Harnett County
420 McKinney Pkwy
LILLINGTON, NC 27546
Phone:
Fax:

SUBJECT: **SFD2309-0035**
SINGLE FAMILY DWELLING

Here are the results of all Inspections located at **115 ITHICA LN:**

Inspection Type: ROUGH IN
Scheduled Date/Time: 4/7/2025
Completed Date/Time: 4/7/2025
Inspector: James T Hall
Result: DISAPPROVED

7/17/2023

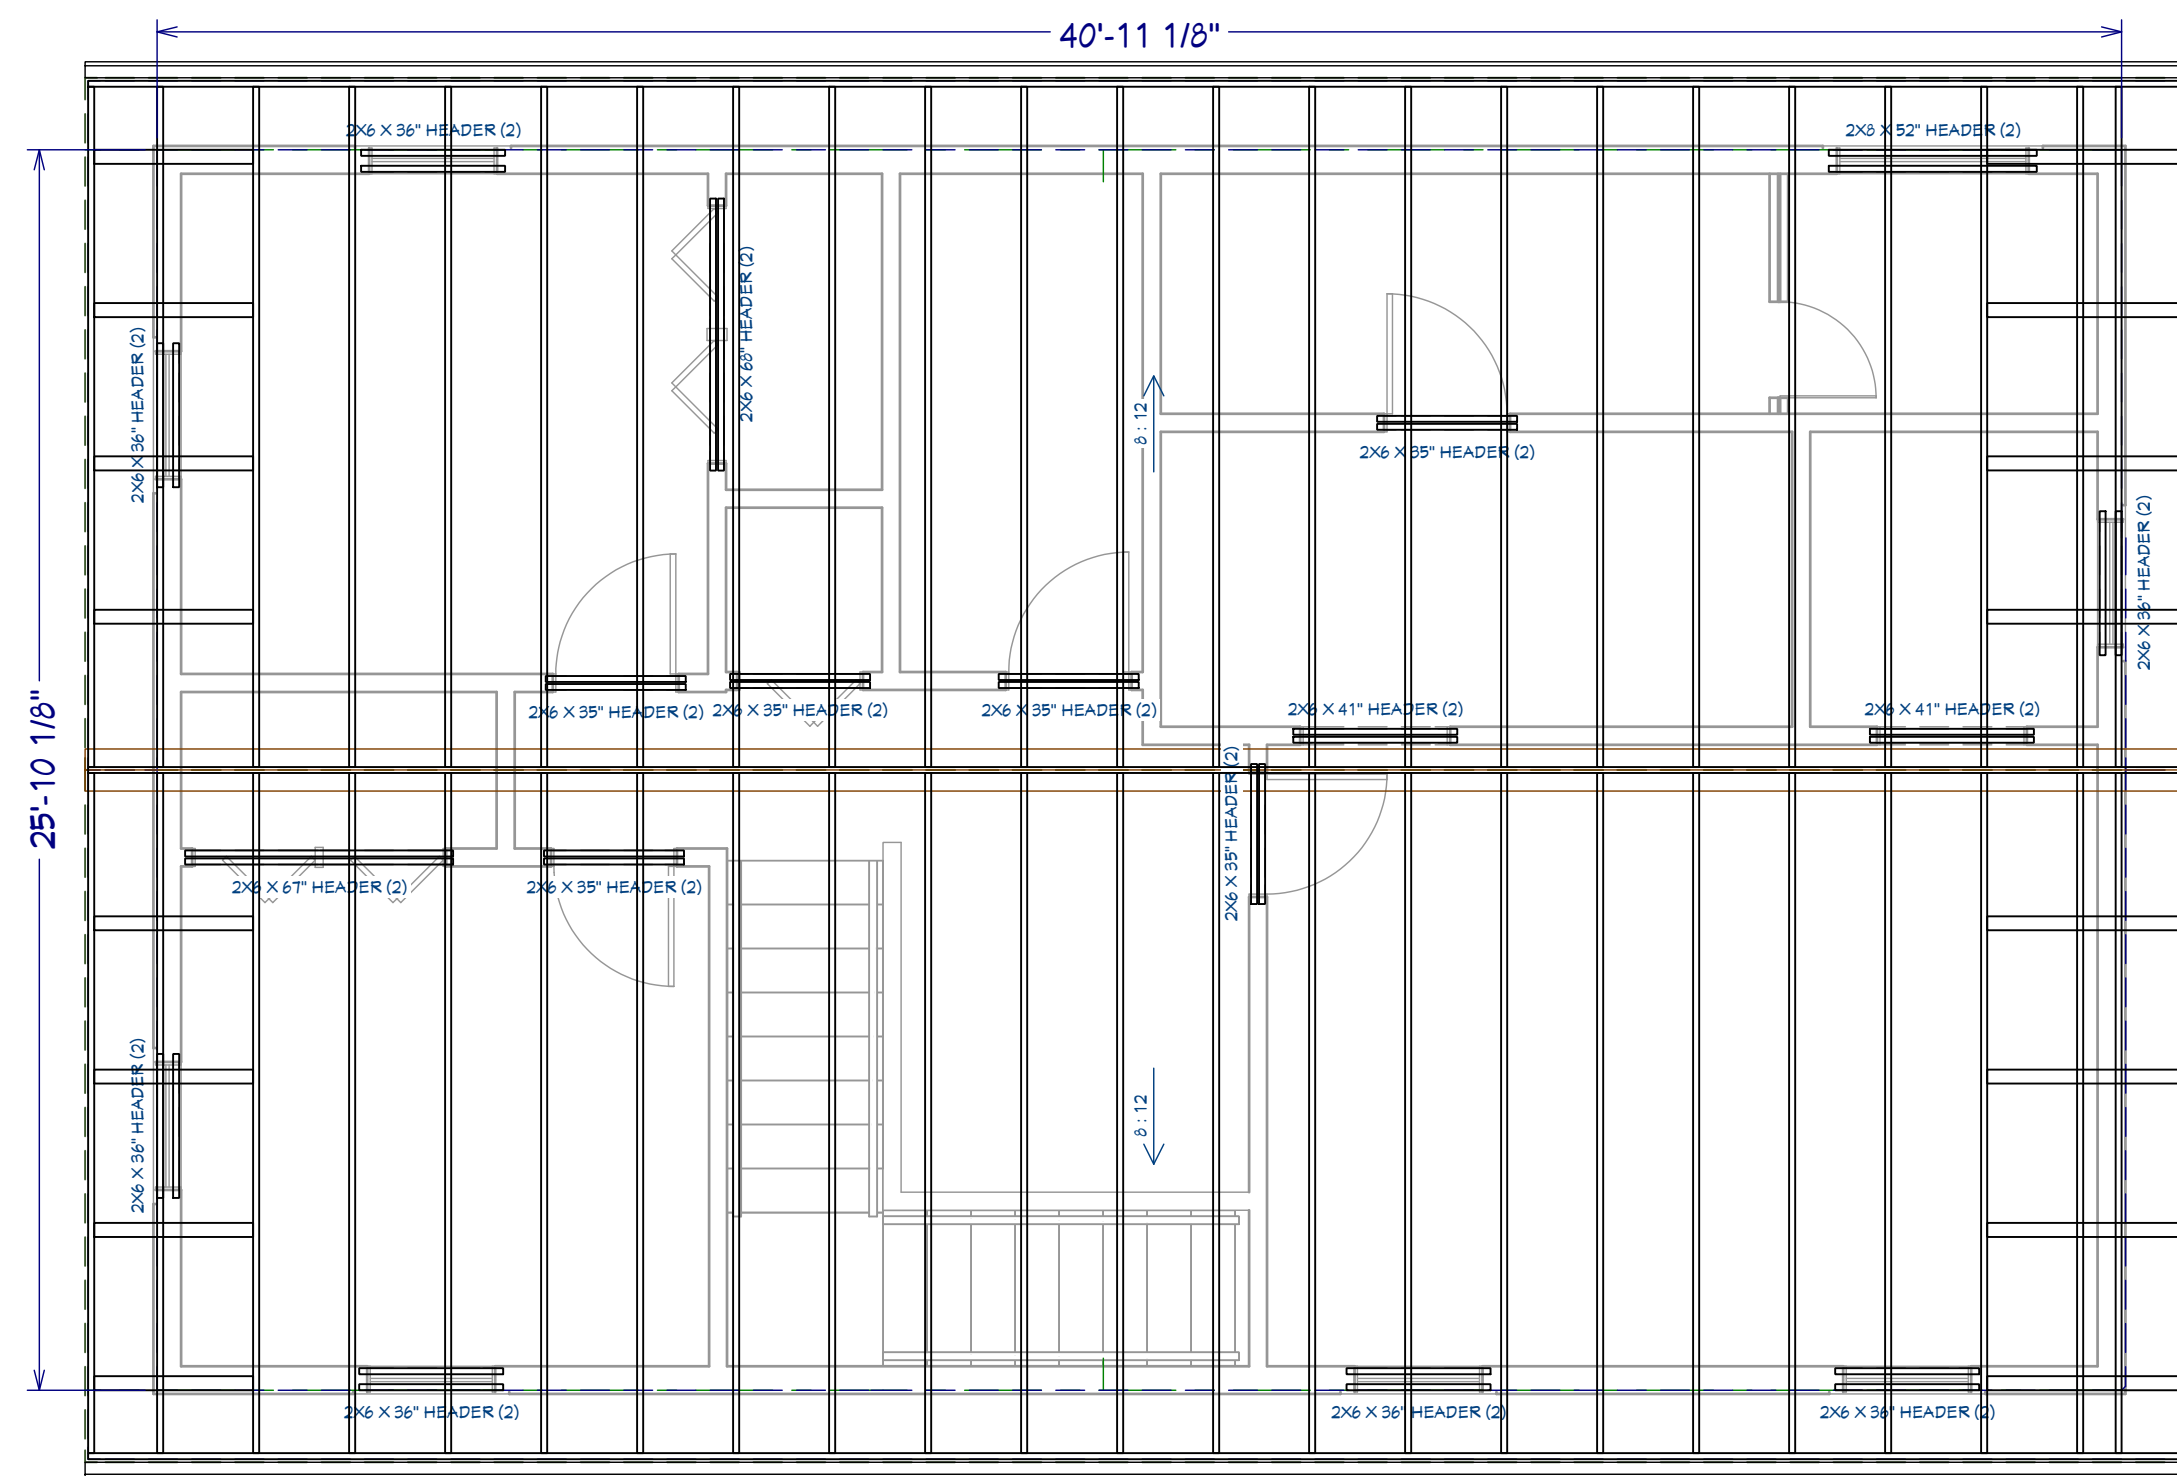
1. House already sided need third party engineers letter on porch beams covered
2. Porch post not installed at time of inspection
3. Nail lvl beam at garage door per documents and need cut sheets for the lvl beams

7. Fire caulk dryer duct at top plate
8. Need correct nail guards on 2" pipe in laundry room
9. Fire caulk hole under dryer box
10. Plans show a lvl beam in kitchen and they have a 3 ply 2x10 beam and need to know the load on the headers where it bares

17. Need letter for damage on 2 ply lvl beam in living room
18. Replace floor joist over back right kitchen door over notched and bored in center 1/3
19. Missing nail guard on water lines in kitchen on left wall
